re: Grading and Site Servicing Plans Review

230-232 Lisger Street - Ottawa, Ontario

file: PG6401-MEMO.02 Revision 1

DRAWING NAME
 GENERAL PLAN OF SERVICES

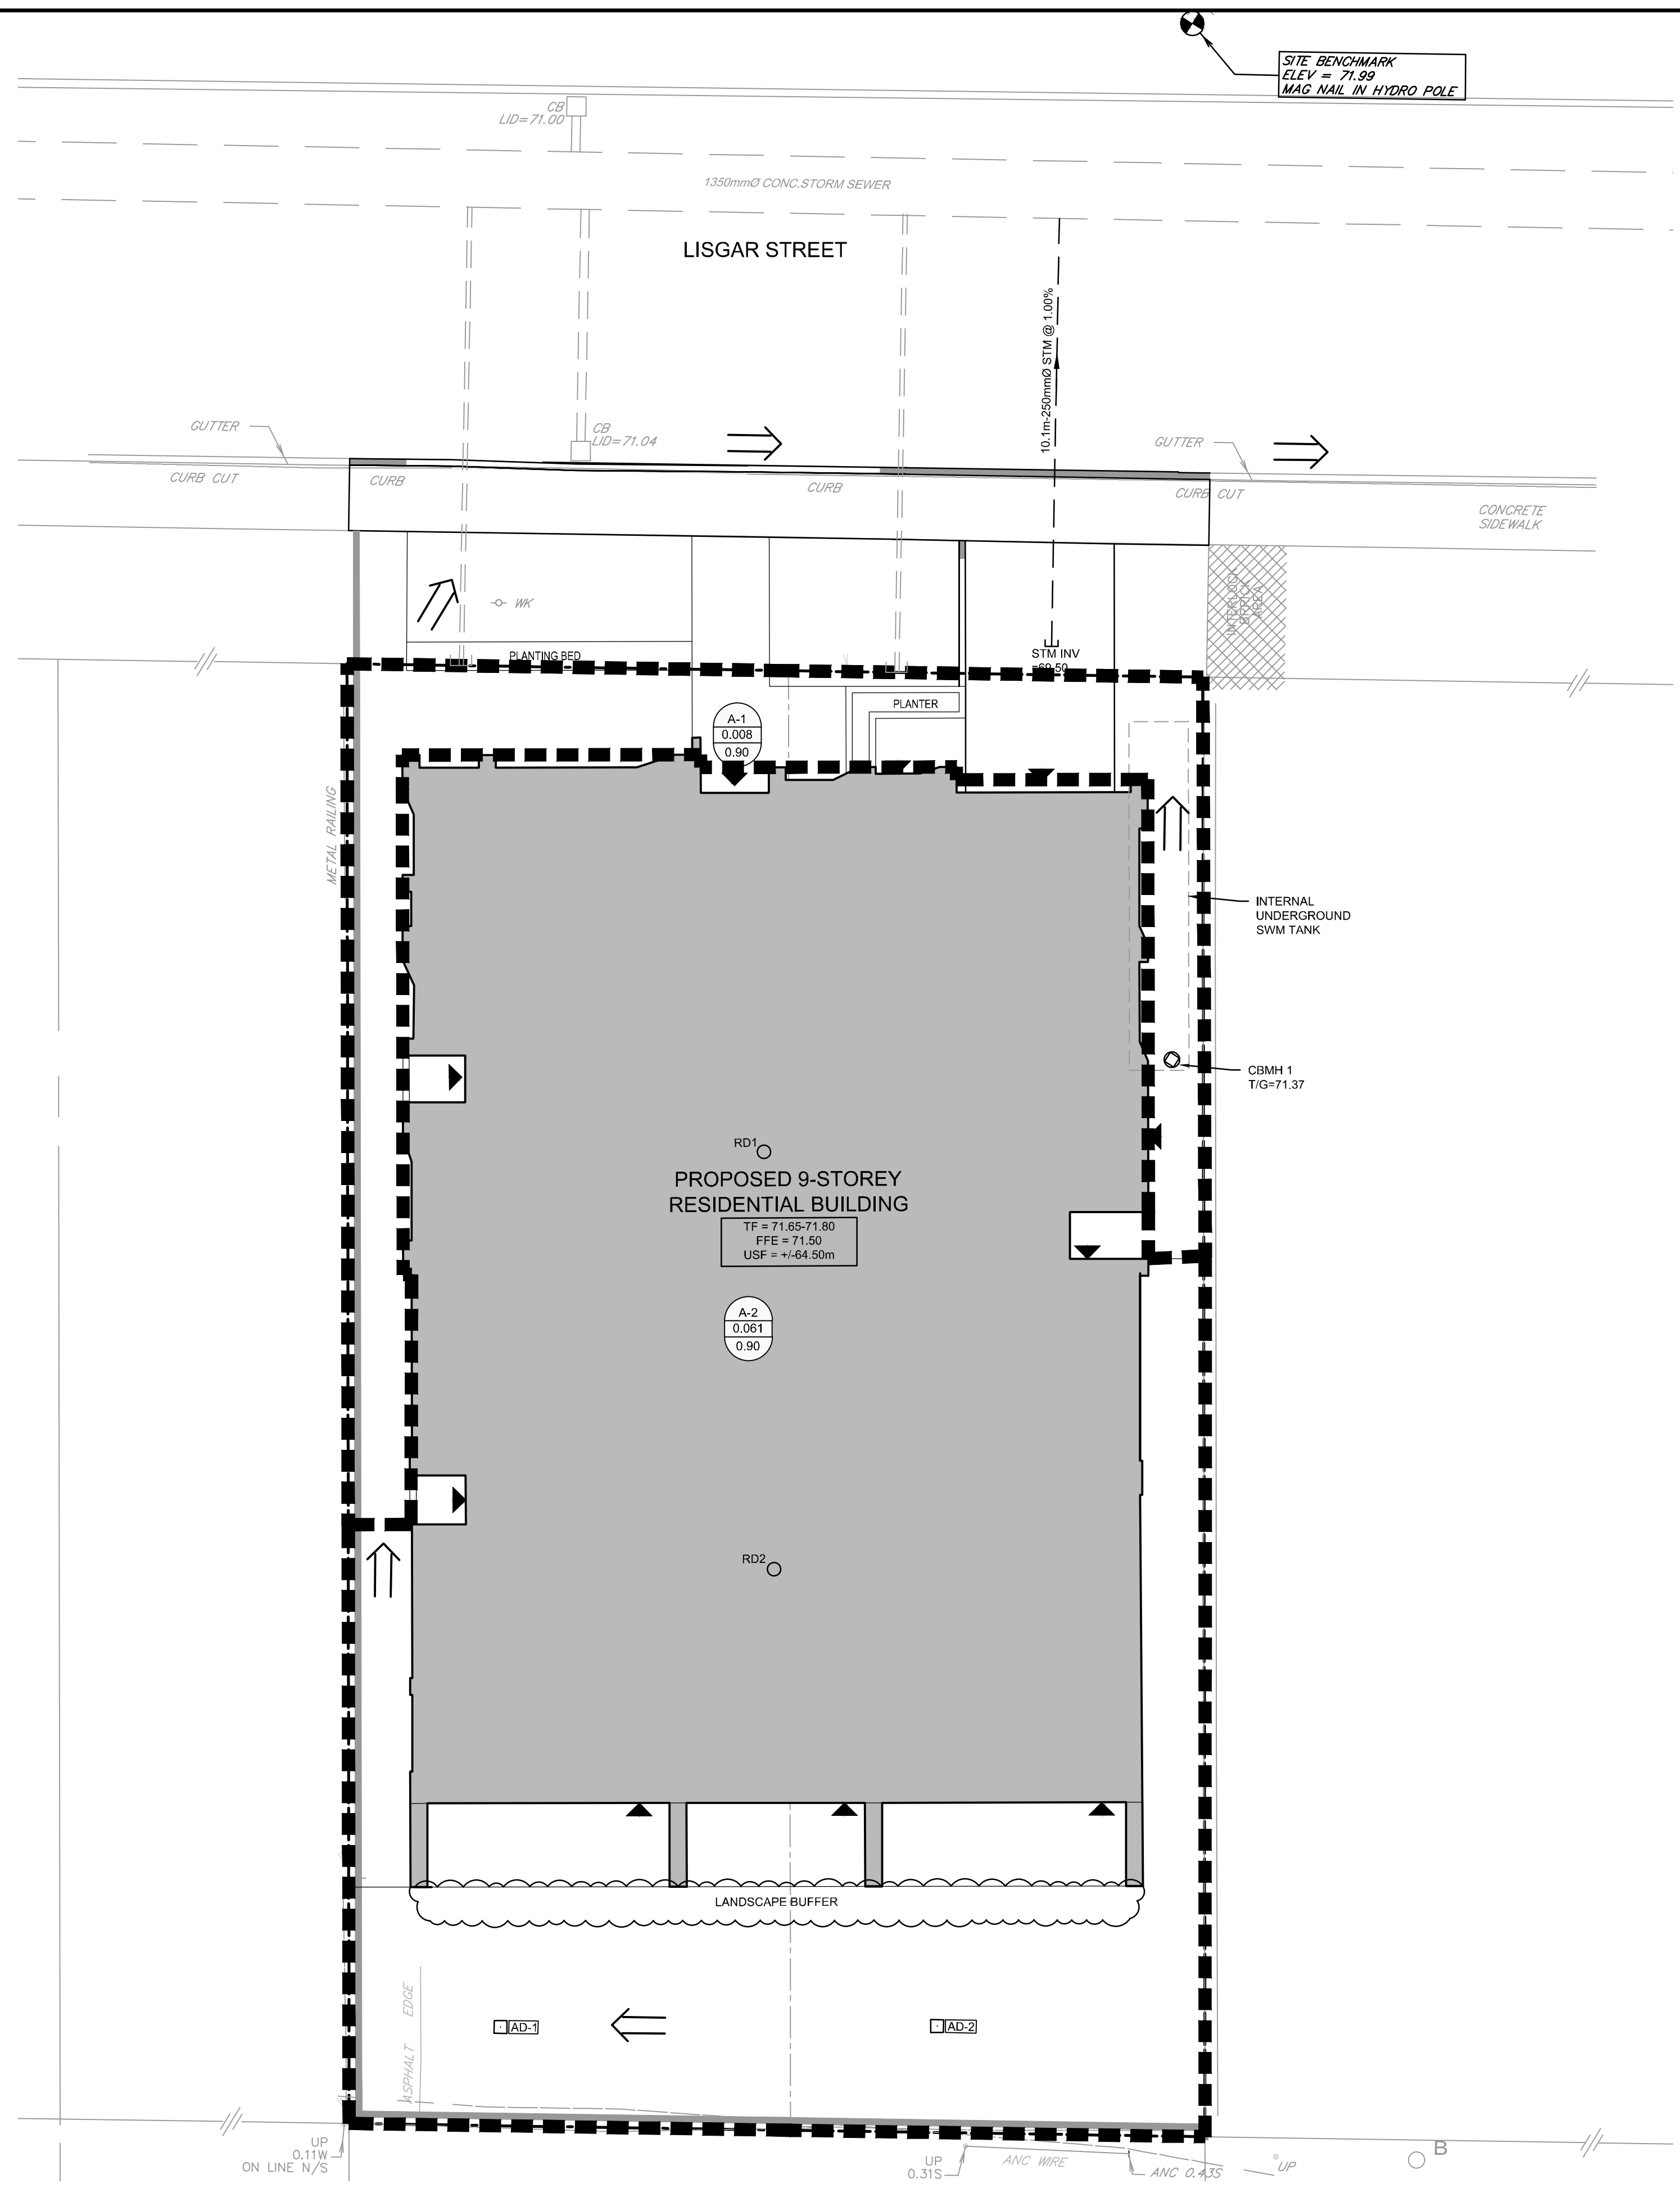
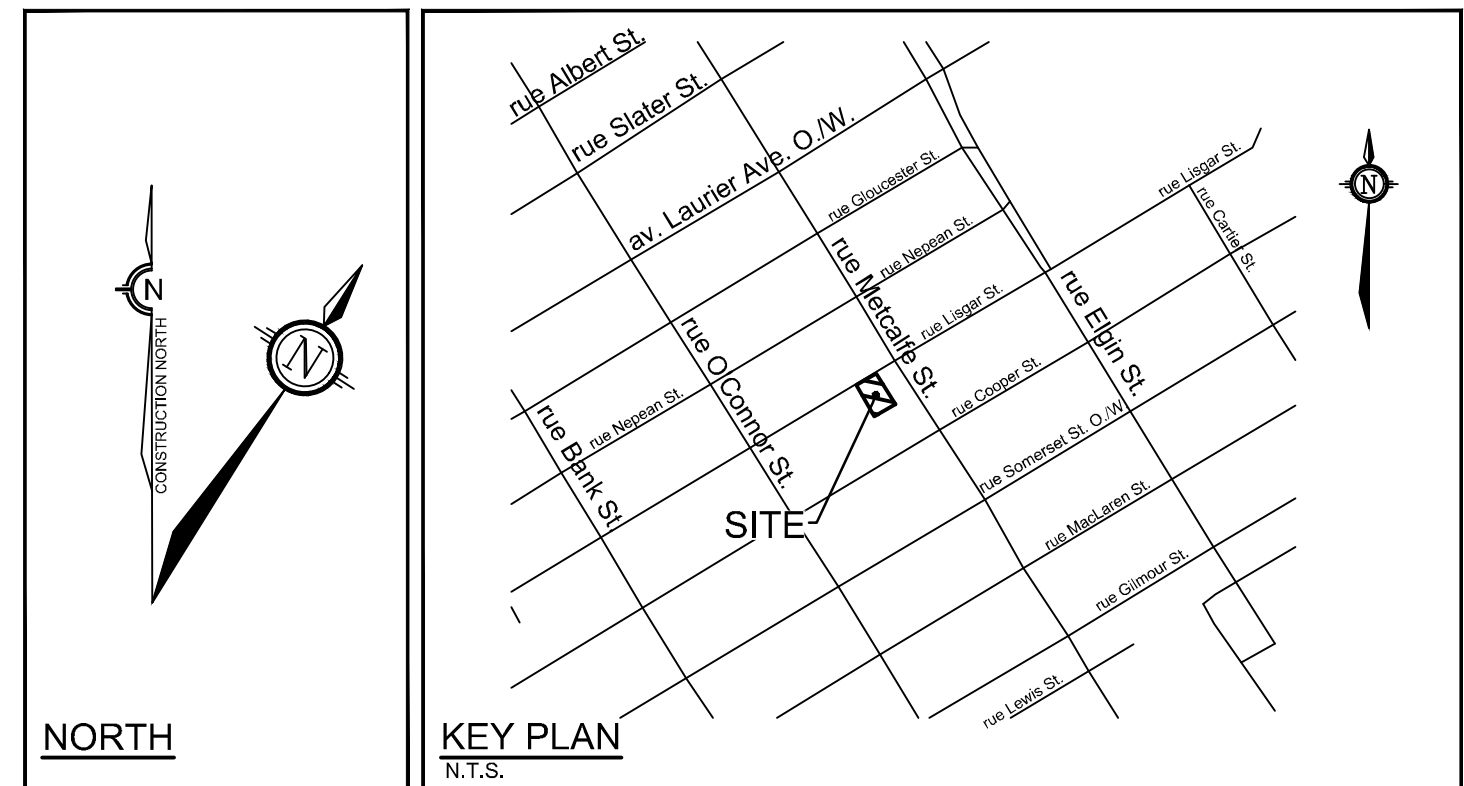
Based on our review of the above noted site service plans, The services were found to be outside of the lateral support zone of the proposed footing and be considered to be acceptable from a geotechnical perspective. However, insufficient frost protection has been provided for the storm and sanitary sewer services. At these locations, the storm sewer services are located within the frost zone, approximately 2.1 m below the finished grade.

Refer to Figure 1, attached to the current memorandum, which demonstrates these approximate locations. In the following section, frost protection of the site servicing is recommended where insufficient frost cover has been provided.

Any portion of the services where the invert level is installed at a depth of 1.8 m below the finished grade or deeper is considered to have sufficient soil cover for frost protection. Where insufficient soil cover is present above the invert of storm and sanitary sewer pipes, the following frost protection criteria should be followed:

Table 1 - Rigid Insulation Recommendations for Storm and Sanitary Sewer Pipes with Reduced Soil Cover						
Thermal	Soil Cover		Insulation Dimensions			
Condition	Provided	Thickness	Extension			
Condition	(mm)	(mm)	(mm)			
	600 to 900	125	Extend 1200 mm horizontally			
			beyond edge face of the sewer			
	900 to 1200	100	Extend 1200 mm horizontally			
Unheated			beyond edge face of the sewer			
Officated	1200 to 1500	75	Extend 900 mm horizontally			
			beyond edge face of the sewer			
	1500 to <1800	50	Extend 600 mm horizontally			
			beyond edge face of the sewer			
Notes: All designs are based on a freezing index of 1000°C-days

All rigid insulation should consist of either Dow Chemical High-Load 40 (HI-40), Styro Rail SR.P400, or equivalent approved by Paterson. The placement of all insulation within the service trenches must be reviewed and approved by Paterson personnel at the time of construction.

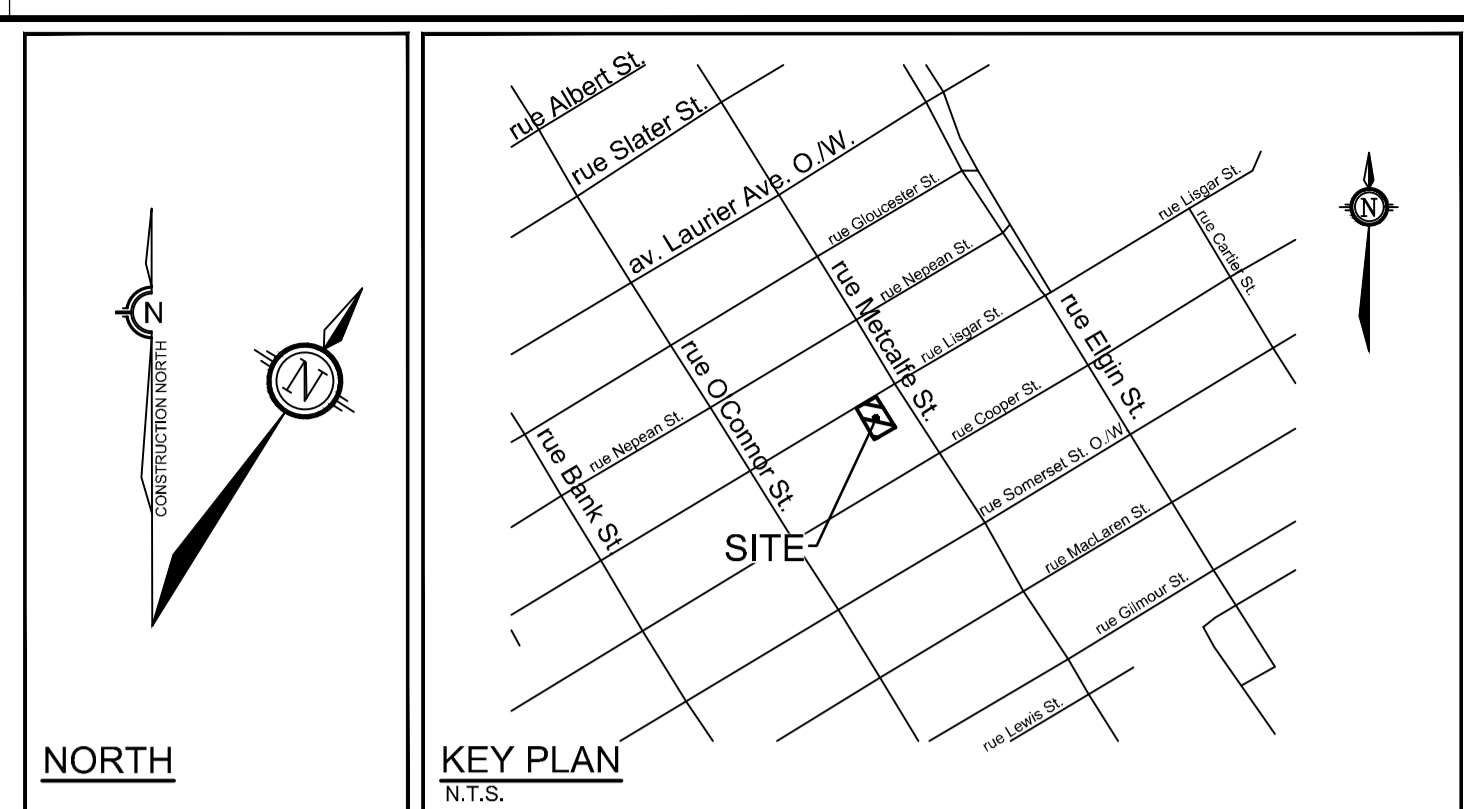
Based on our review of the above noted grading plans, the proposed grade raises within the aforementioned site are within the recommended permissible grade raise of **2.0 m**. No exceedances were noted for any area within the subject site. Therefore, the proposed grade raises are generally acceptable from a geotechnical perspective and will not require the use of lightweight fill at this time.
